May 16, 2022

Re: Jersey Mike's Subs
1624 NC 24-87 Highway
Cameron, NC 28326

A-103
SHEET 3 OF 10

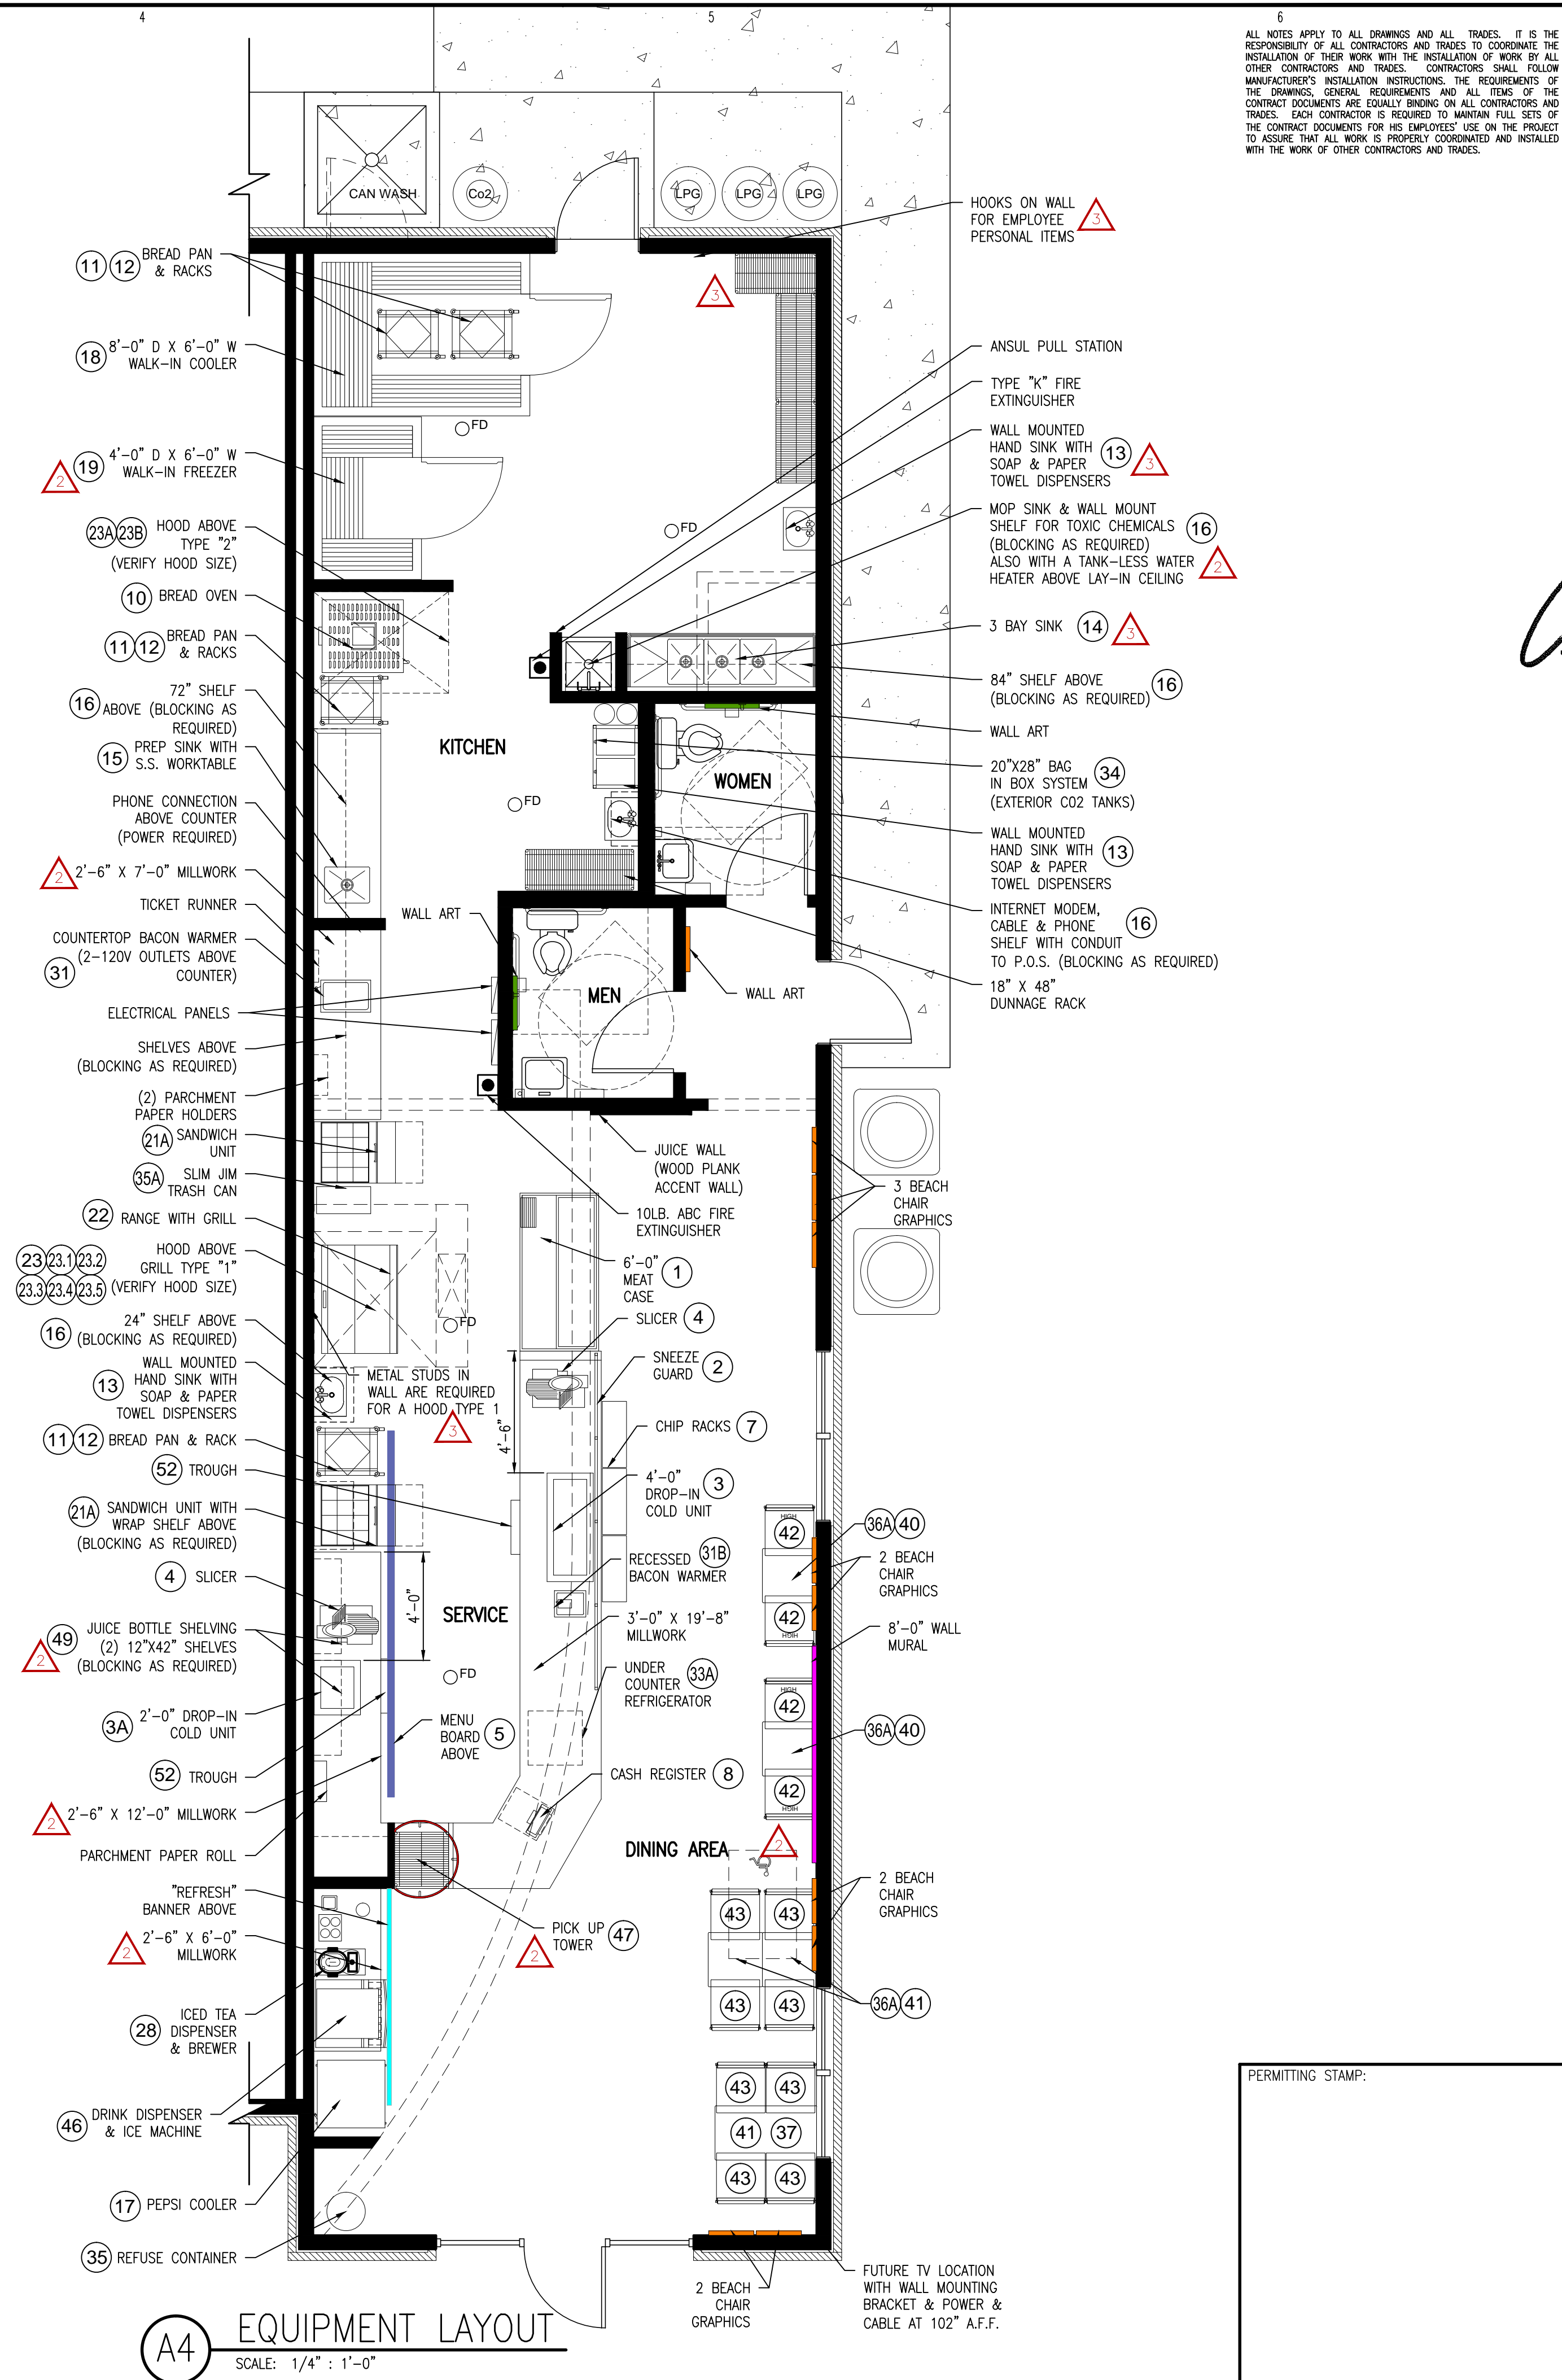
The 5-ton air handlers to sit on the proposed equipment platform only weight 170 pounds each. The method of framing and attachment of the equipment platforms/toilet ceilings with a ledger and joist hangers is perfectly acceptable. The minimum fastener for the ledger to studs would be two 16d nails. The Simpson SDWS timber screws and short-sapn 2x4 framing are more than adequate to support the wieght.
